Department of Planning & Infrastructure

**RE: MODIFICATION OF THOMAS ST CAR PARK DEVELOPMENT APPROVAL
(MP09_0066 MOD 2)**

I refer to the second application to modify the approval for MP09_066 for development of the Thomas Street car park site in Chatswood. I note that the modification concerns changes to conditions B9, B10, B11, C15 and E40.

D4 RAINWATER RECLAMATION TYPE 8 SYSTEM DETAIL
NOT TO SCALE

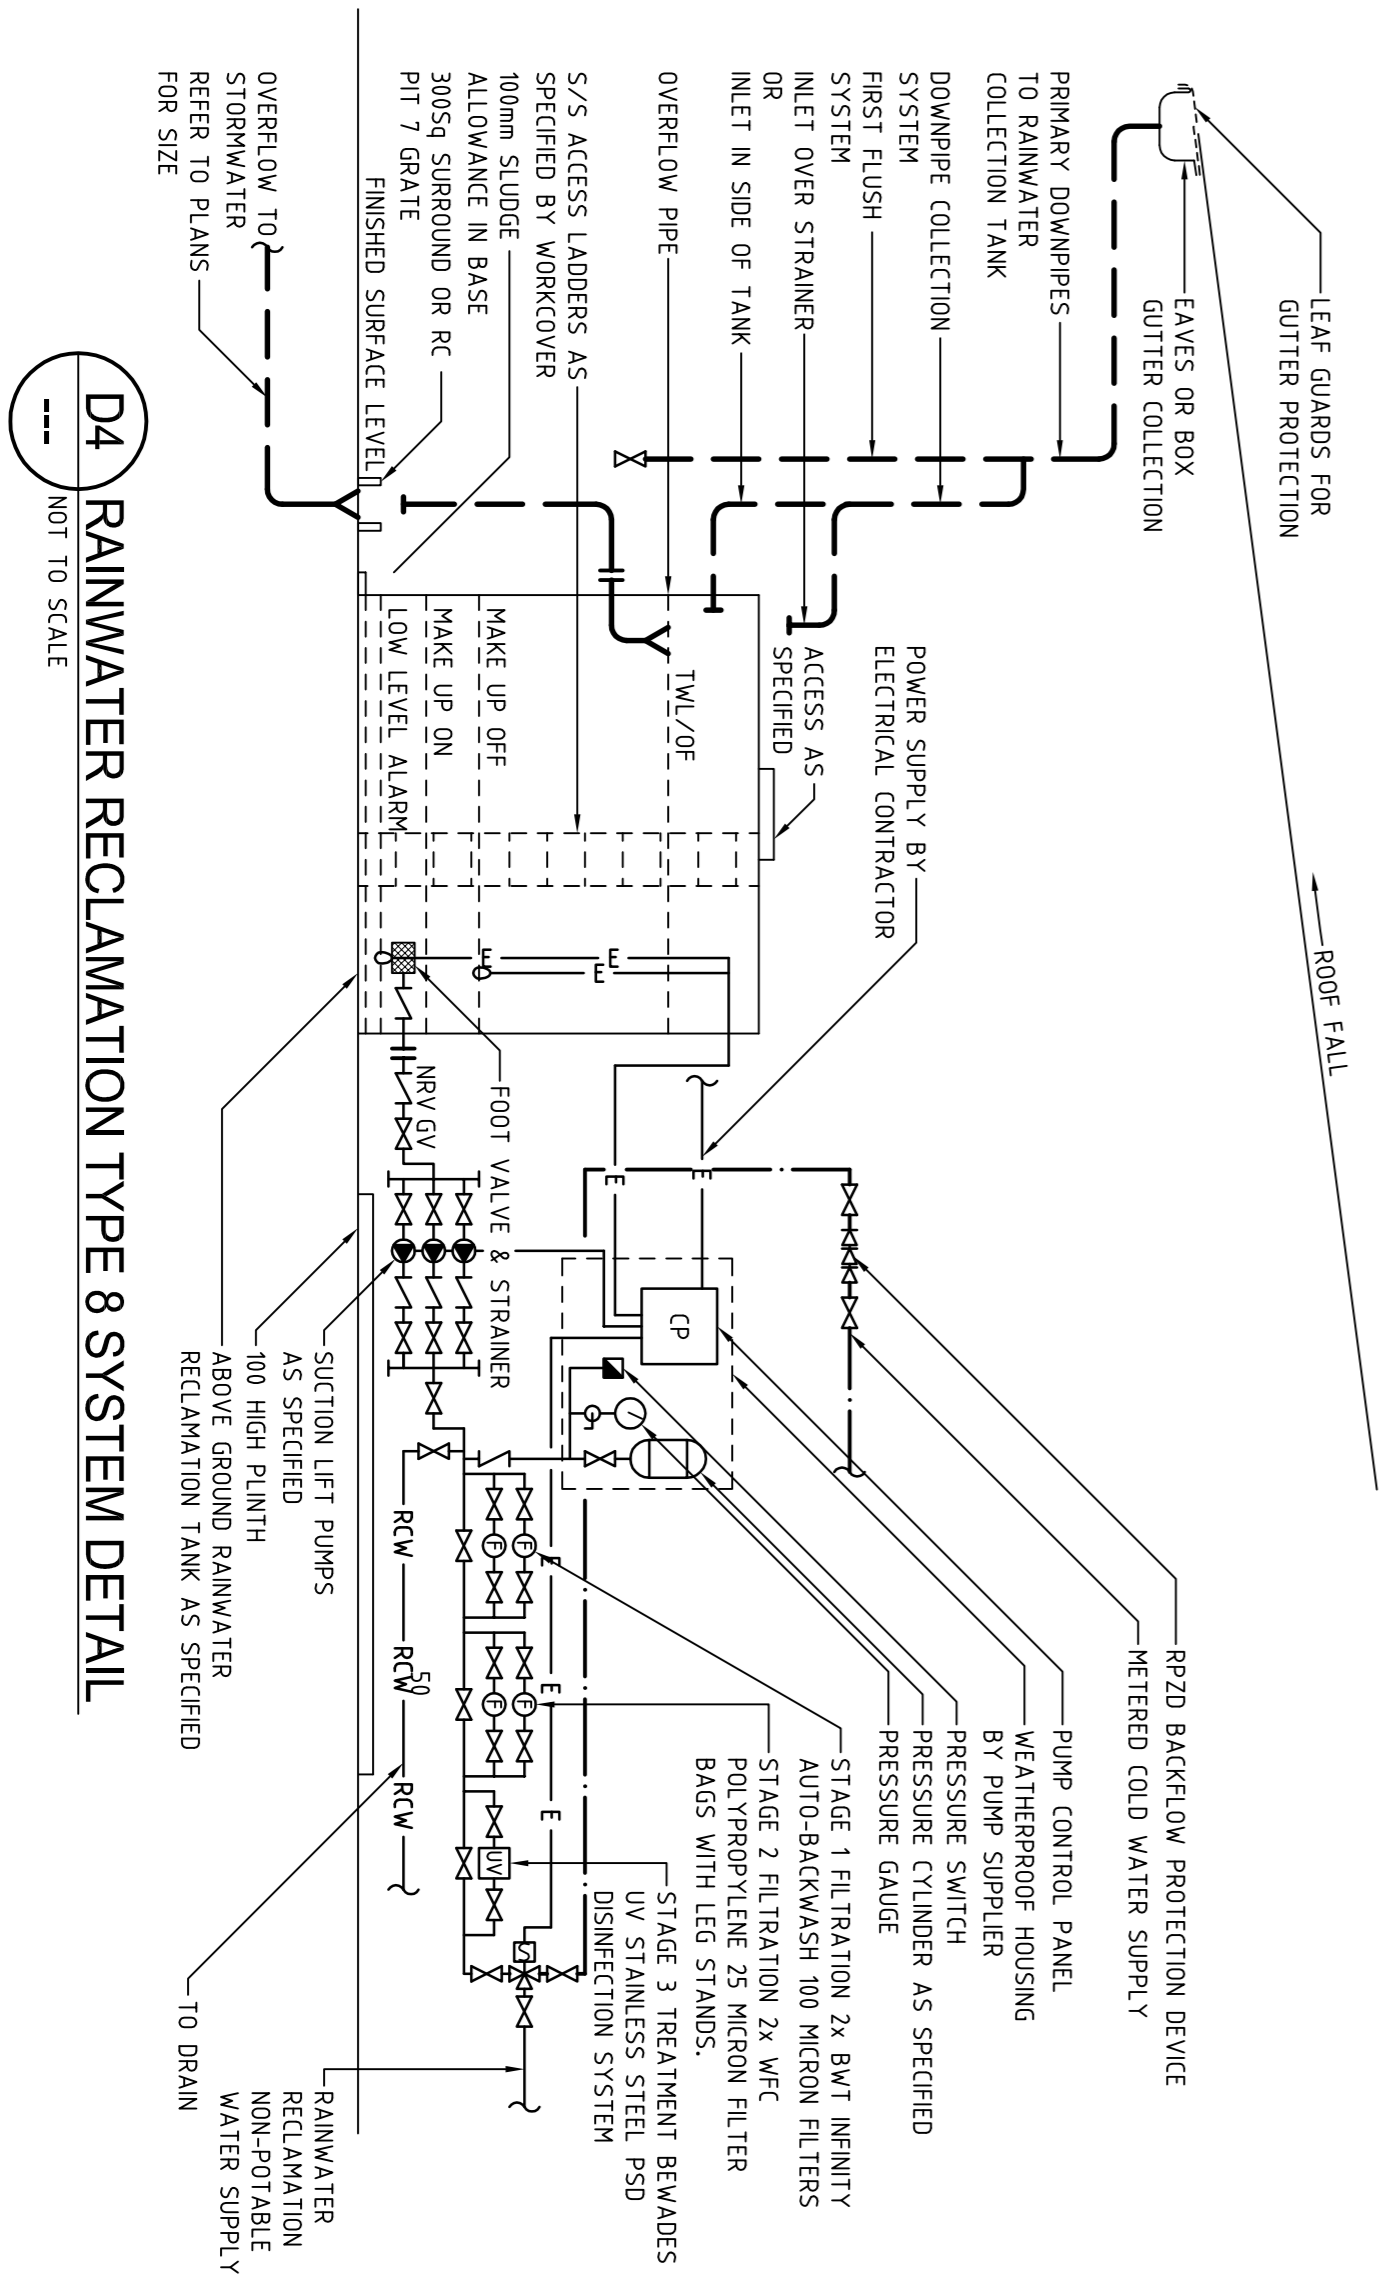
The condition requires rainwater detention and re-use systems be provided on site in accordance with WDCP and Council's Technical Standards. The requirement is not new and the condition is not unreasonable noting that as an integrated system the capacity of the rainwater re-use system and the detention system are interrelated and complementary. Council has been applying the requirement for a number of years consistent with water sensitive urban design principles.

BASIX provides a minimum standard for water saving that is easily improved upon and should not be considered as a maximum. This is the inference of the requested change to the condition. Council considers that Meriton as a market leader in the development of residential should also be a leader in sustainable initiatives. I note that the condition is a standard form applied to all similar development in Willoughby. Rain water re-use for as much as possible non-potable water needs such as laundry, toilet flushing, car washing, landscape irrigation and so on is responsible sustainable design. The condition of consent as currently worded provides certainty in respect to design standards and storage volumes. The requirement that there be an overflow to an on-site detention tank is to manage the excess capacity needed for high volume storm events and to minimise the flush of an overflow into Council's stormwater system.

Council objects to the request to change Condition B10.
